## **SSD 7382 MOD 1 - RESPONSE TO REQUEST FOR ADDITIONAL INFORMATION UTS CENTRAL**

This letter is in response to a request for additional information for the proposed Section 96 Modifications to the UTS Central Project (SSD 7382). This letter has been prepared by JBA on behalf of the University of Technology Sydney (UTS) and is based on supporting documentation including:

For Information **DA S96 2204[B]**

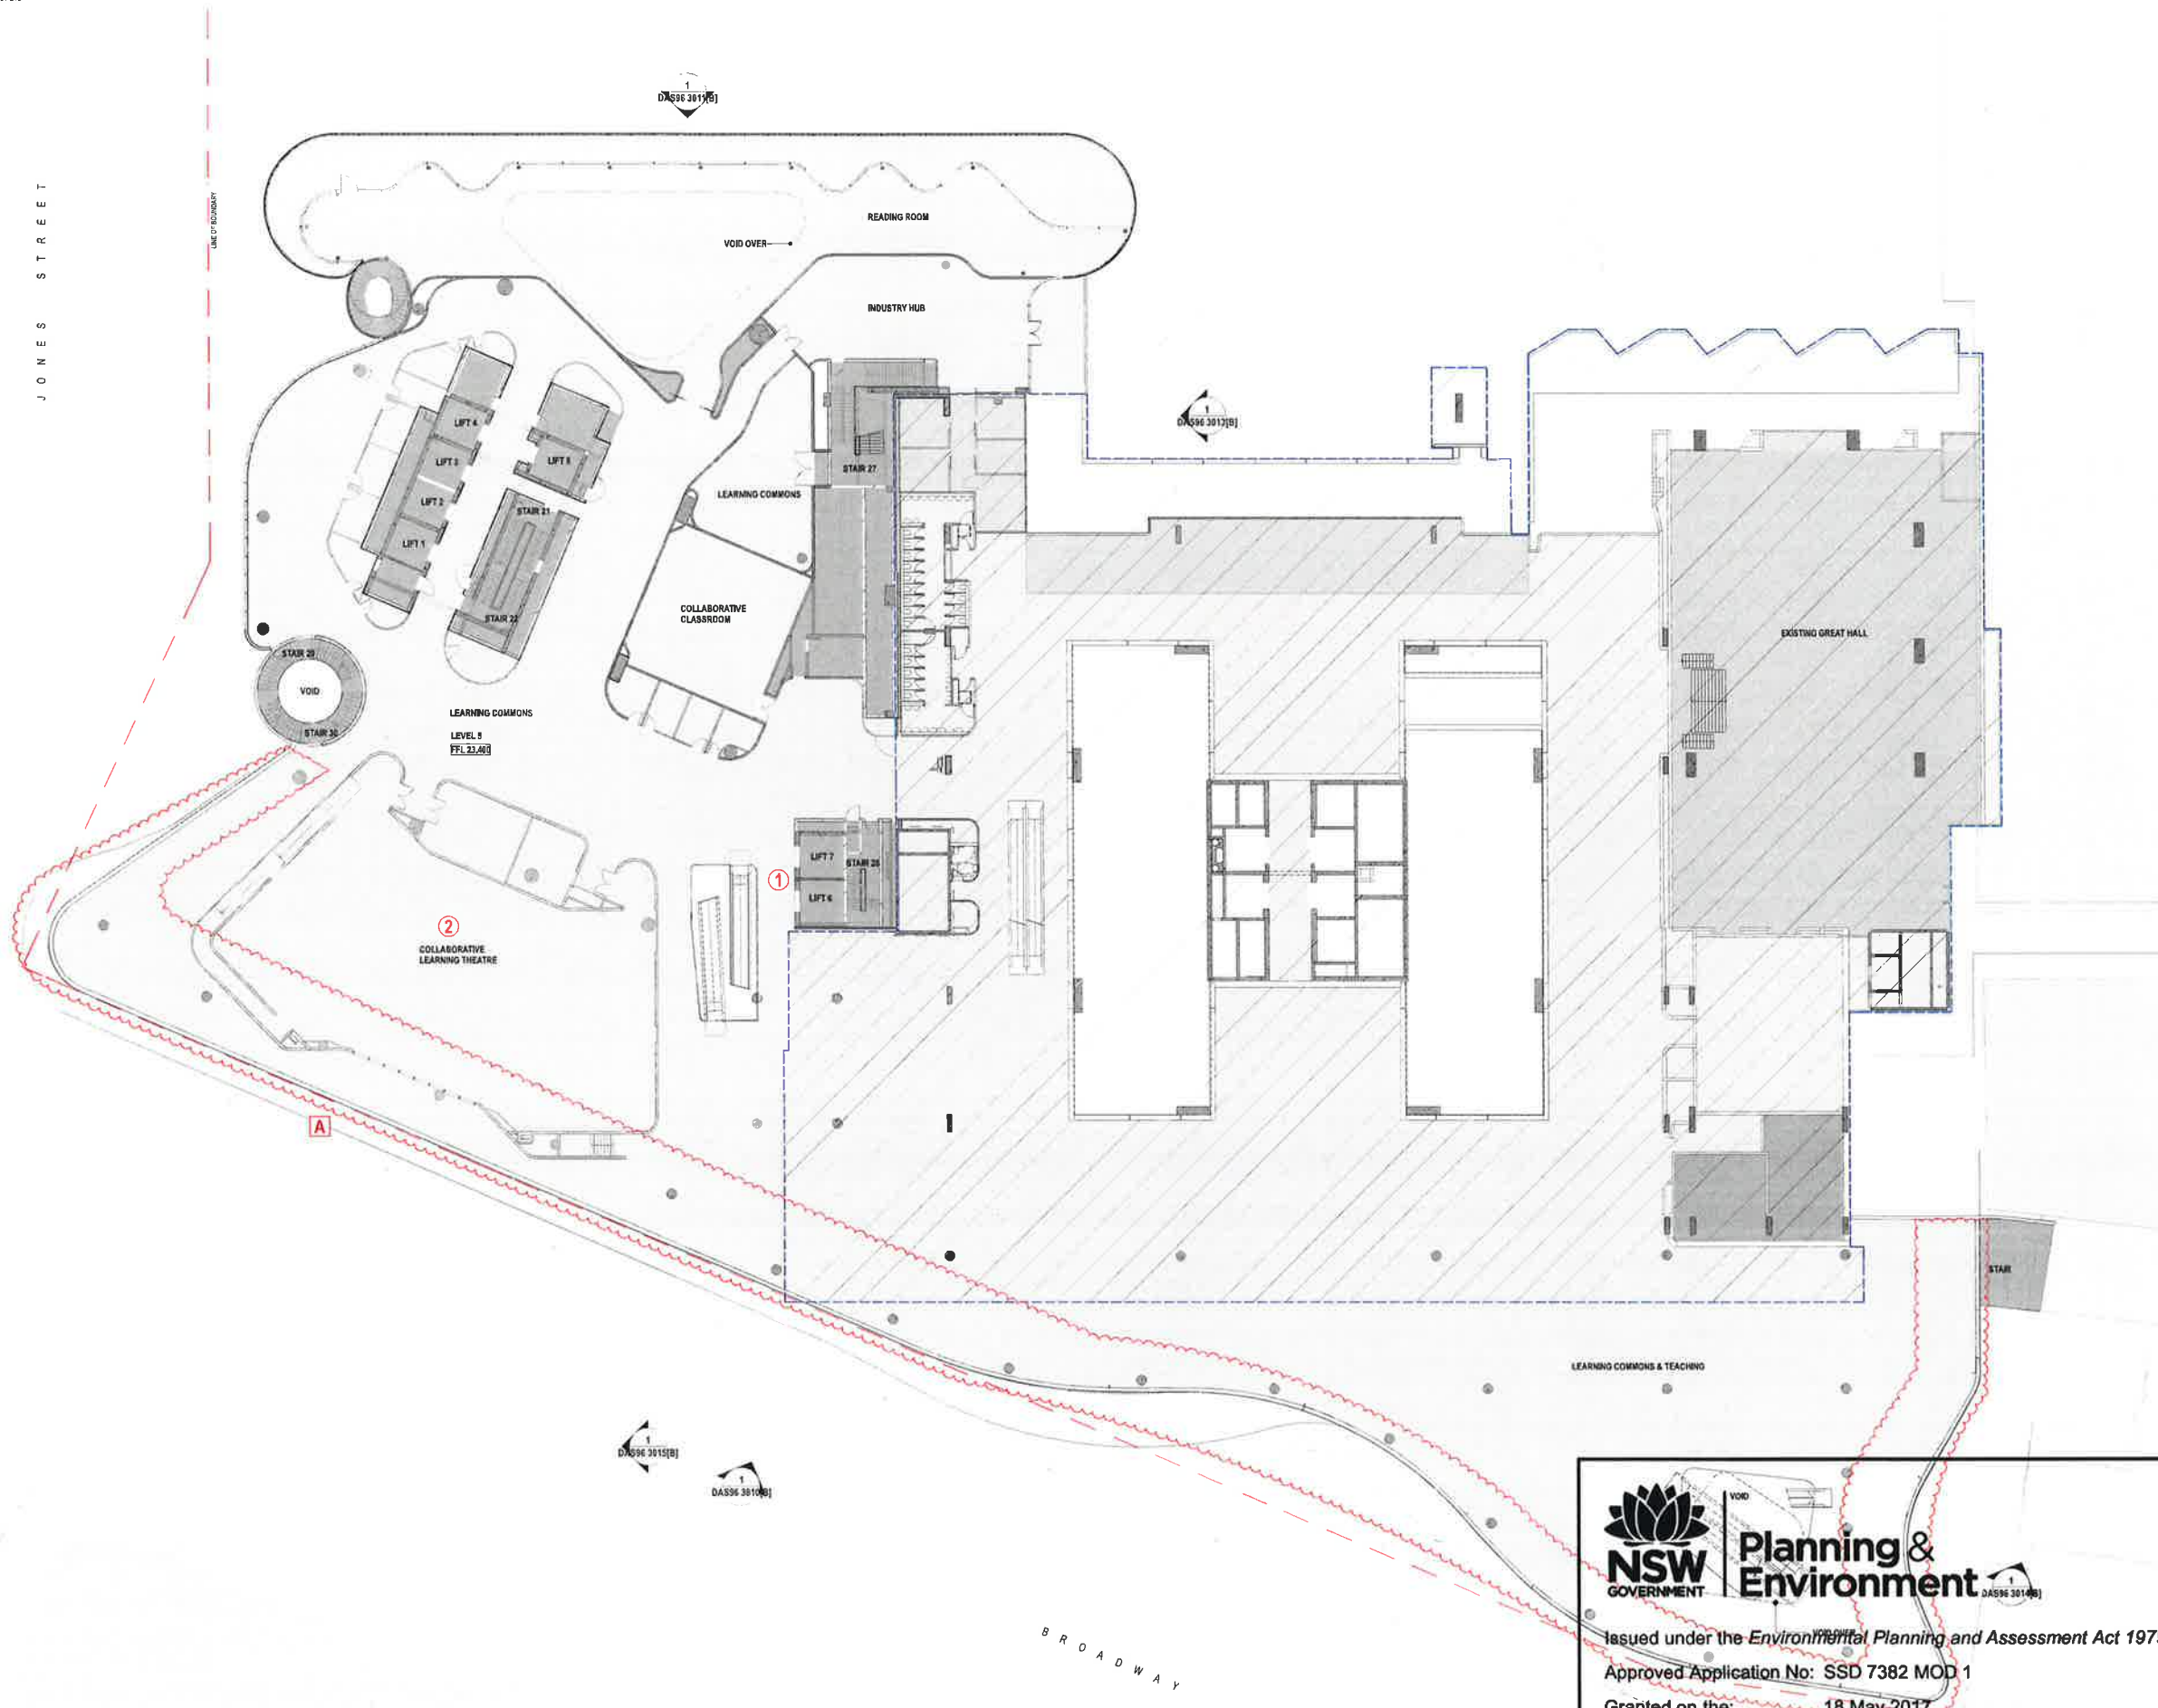
*Clarification should be provided in relation to conflicting information regarding the Collaborative Learning Theatre, which appears to have been replaced by three single storey General Teaching Spaces. Further justification and detail is required to support this modification, including ceiling heights, program, entry and circulation and capacity; and*

*Further details regarding the program for the General Teaching Spaces and the Learning Commons and how they would provide activation of the façade must also be provided, particularly whether any entry to the CLT space/s is proposed on the façade side. Without a designated circulation path around this side of the CLT, it is unlikely that this space will be used given the width of this space and therefore is unlikely to achieve the aim of activating the façade.*

- **Appendix A** confirms in writing and diagrammatic form that the General Teaching Spaces (GTS) as identified in the S96 are the same spaces that were incorporated into the DA as Collaborative Learning Theatres. Both terms can be used to describe the use of these spaces.
- These spaces are as shown in the DA with the same proposed ceiling heights, programme, circulation and capacity. The only change that has occurred is the shape of these spaces as a result of adjusting their position to be more central on the floor plate and away from the facades on Broadway and Jones Street.
- The GTS on Level 7 has been relocated to the Broadway façade to occupy the same location of the larger GTS on Levels 5 and 6.
- The adjusted location of each of the GTS' provides a much improved relationship with the Broadway façade allowing informal learning spaces to be located between the GTS and the façade.

- **Appendix A** confirms in text and diagrammatic form that locating the GTS more centrally and away from the façade on Broadway and Jones Street provides a place on these floors, adjacent to the facades, for Learning Commons and 'destination spaces' previously not provided for in the DA.

- Provision has been made for greater access to the GTS on the north side and on the south side (Broadway façade side) to more evenly distribute access to and from the GTS and therefore further activating the façade along Broadway and Jones Street.

- These spaces address the Broadway façade allowing informal learning and activated areas to occupy the space adjacent to the Broadway façade which would be very visible from Broadway.
